EP/75/13 - 34 Tamarisk Way, East Preston

For the attention of Mr Sullivan
EP/75/13 – Little Thatches, 34 Tamarisk Way

05/2975/1

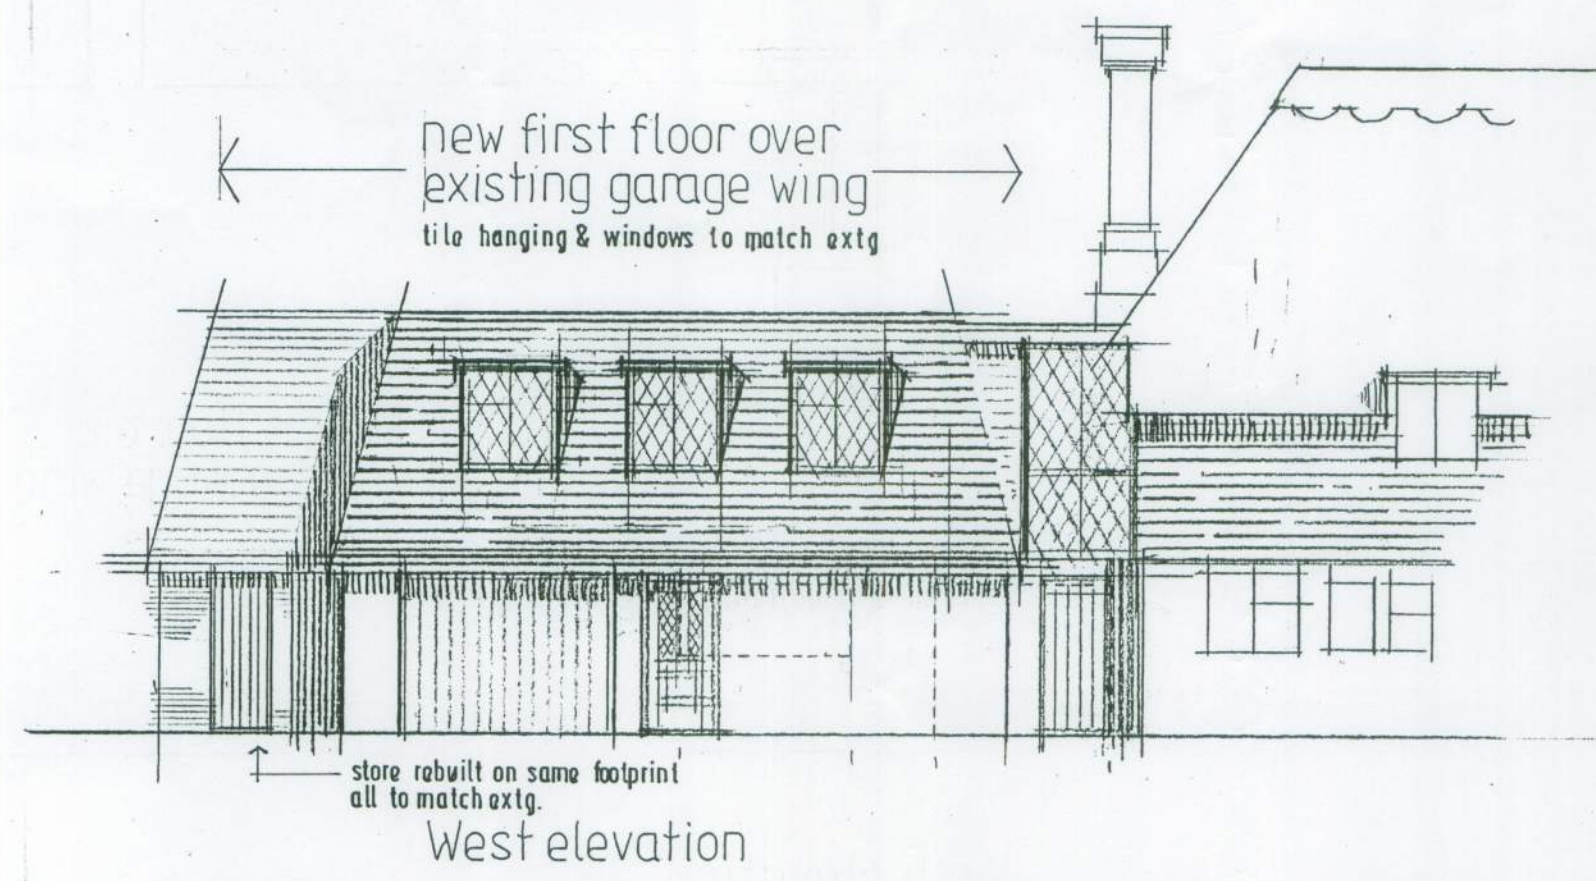
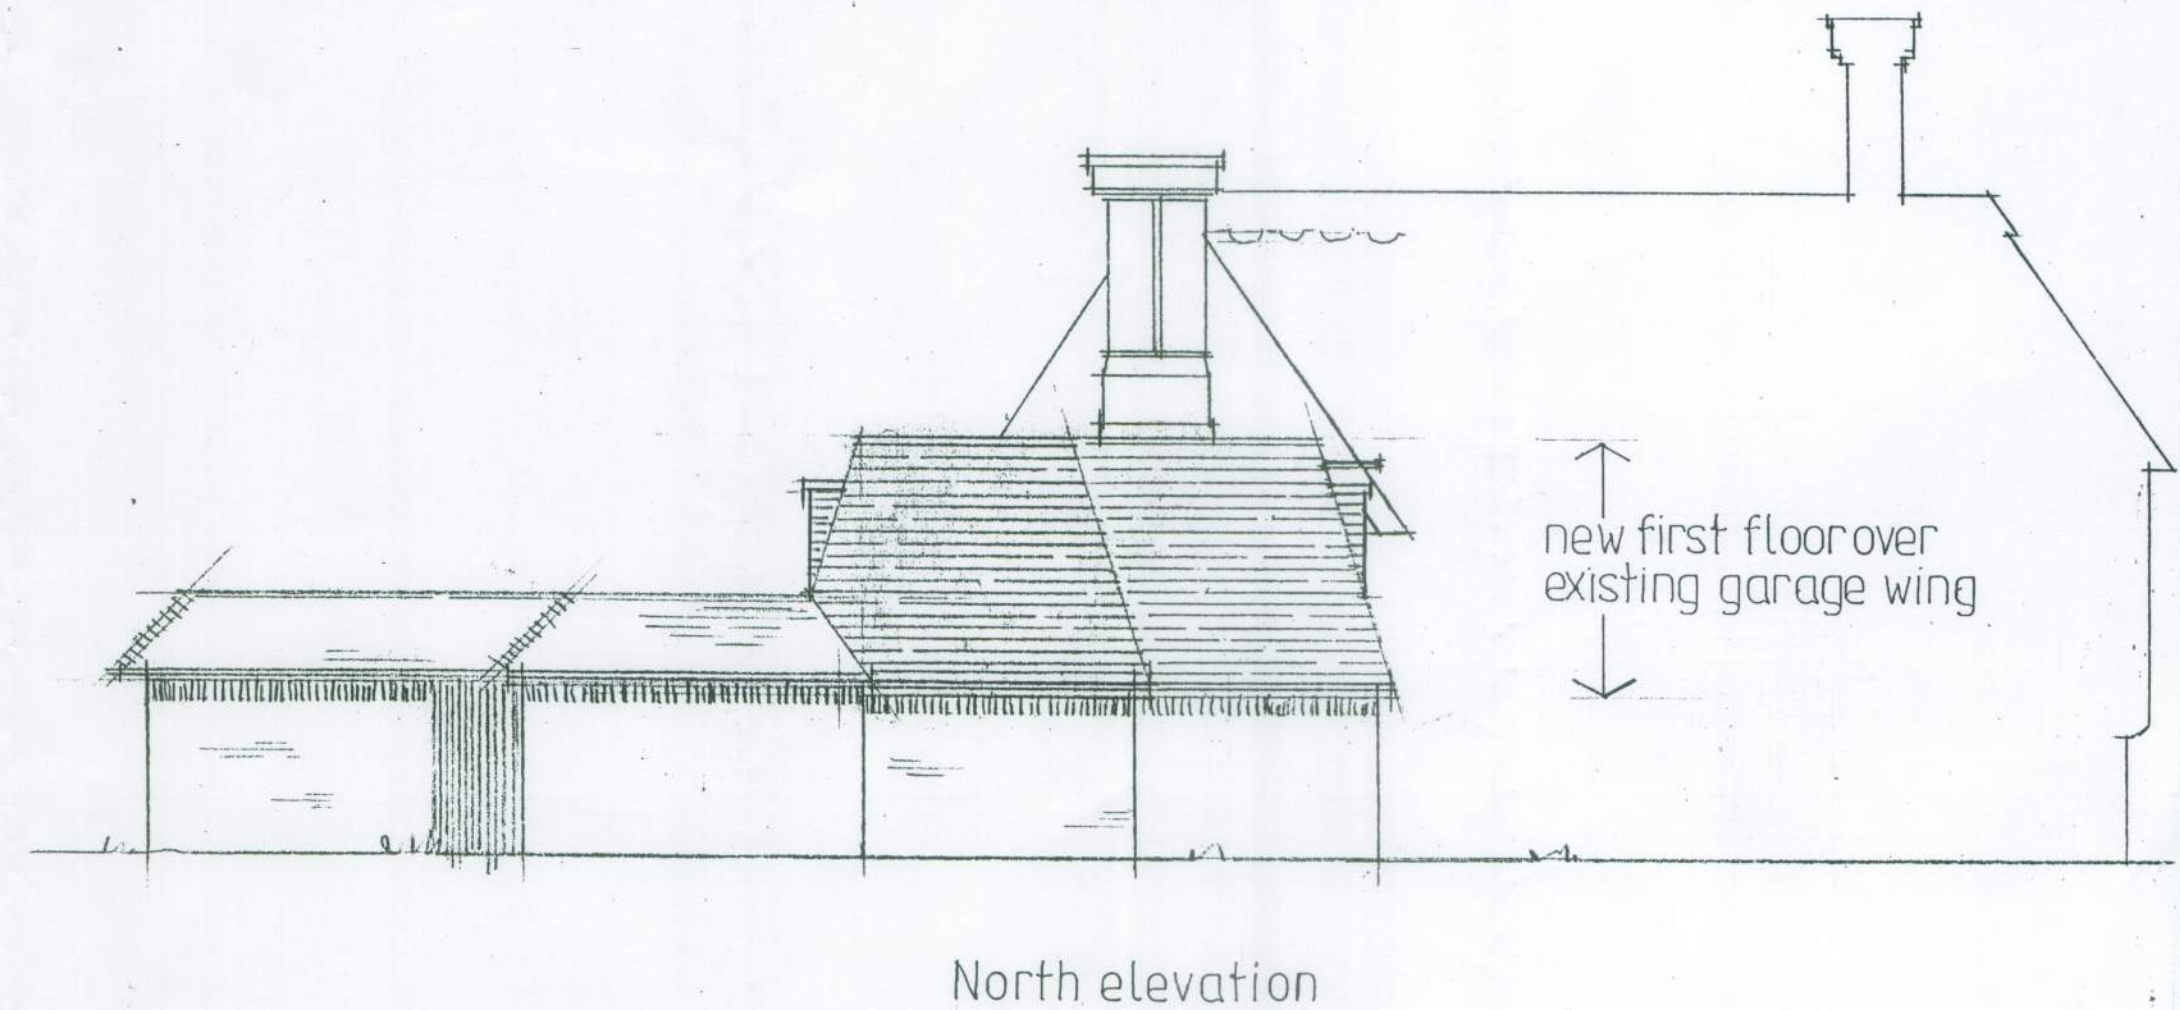
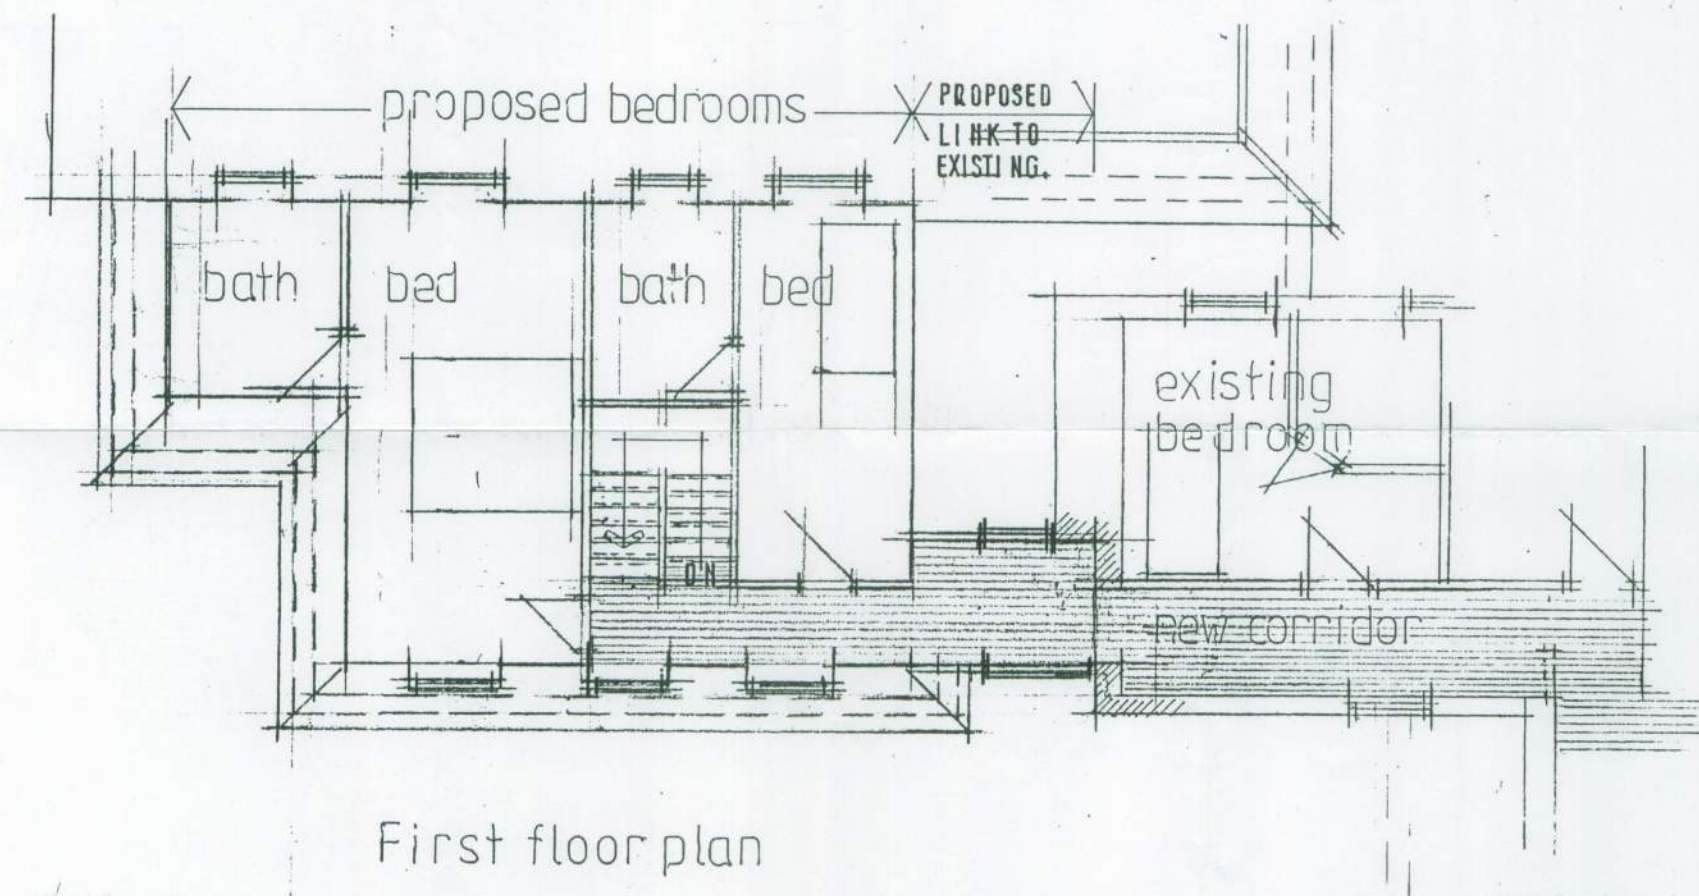
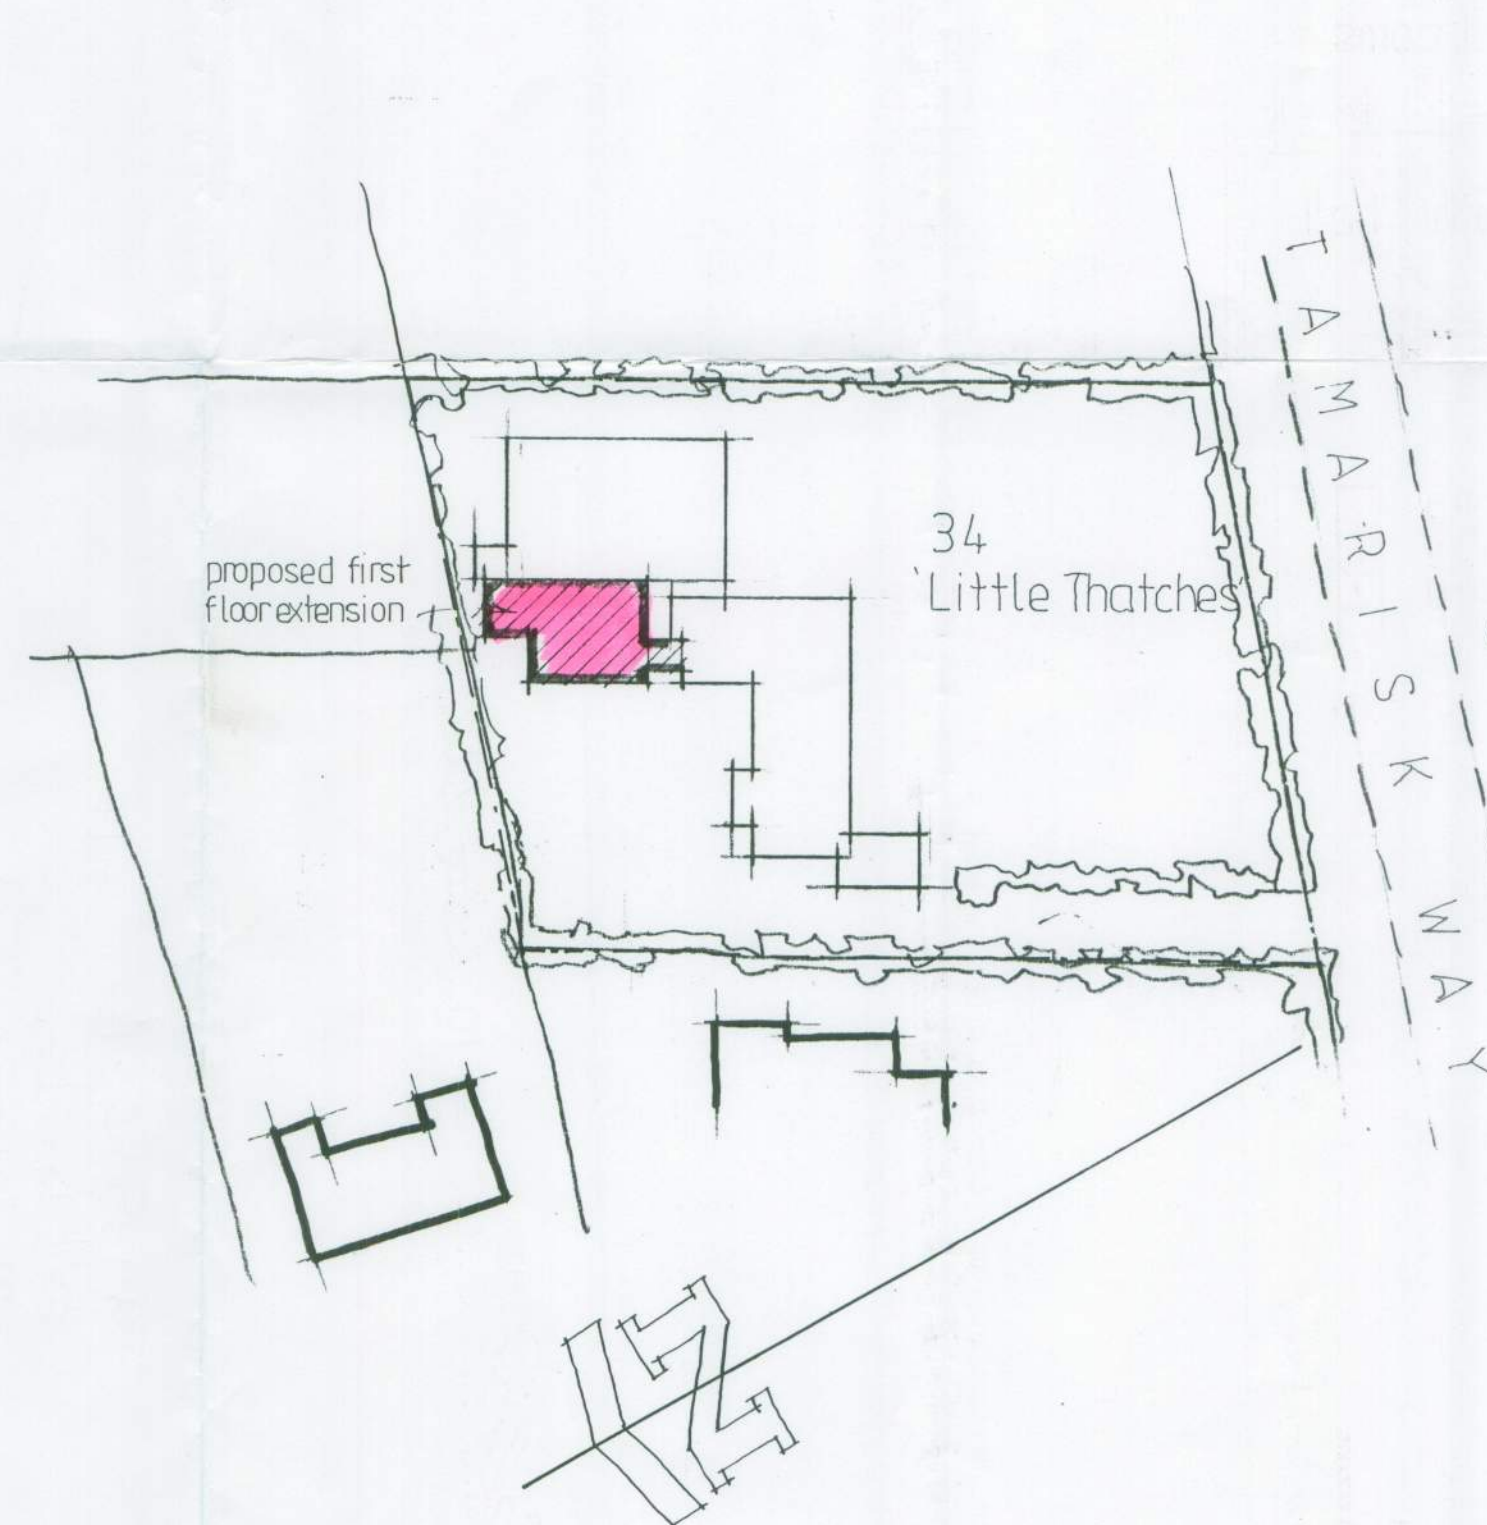
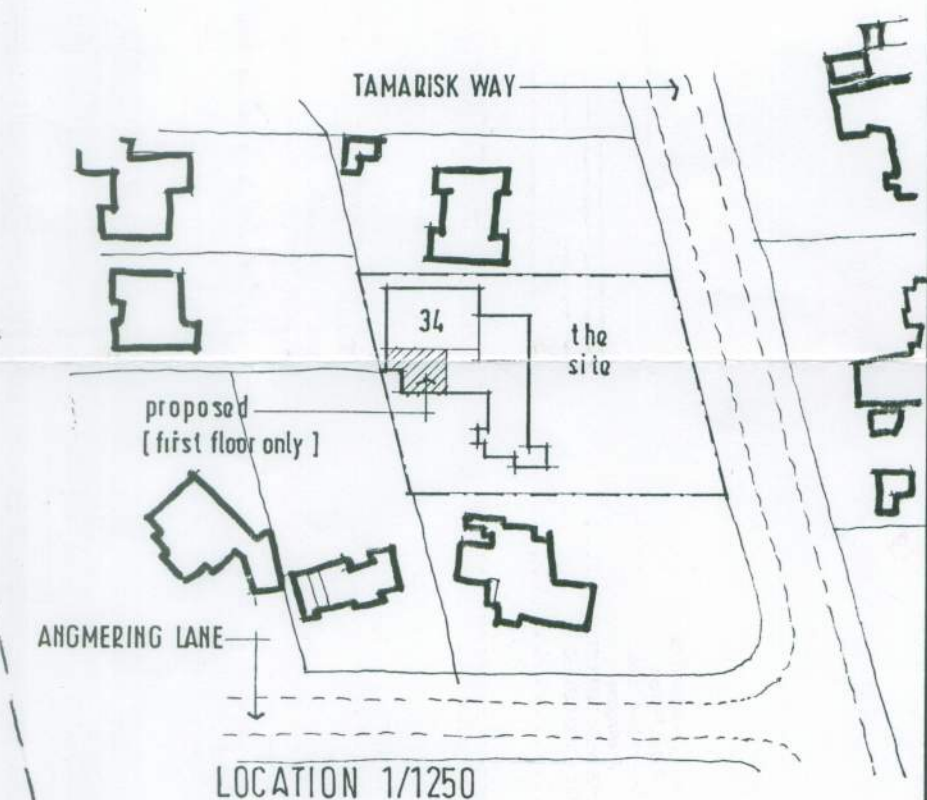
The owners of Little Thatches presently own a single storey building, the flat roof of which we can just see above our fence. This building abuts the fence and there is very little clearance between it and the fence although the plans do not indicate the dimensions of this clearance.

The application for planning approval is to add a complete storey to make it into a two storey building. The resulting development will tower above the fence, be out of scale with other buildings we can see, will prevent sun and light from the south getting into part of our garden and will deprive us of all privacy.
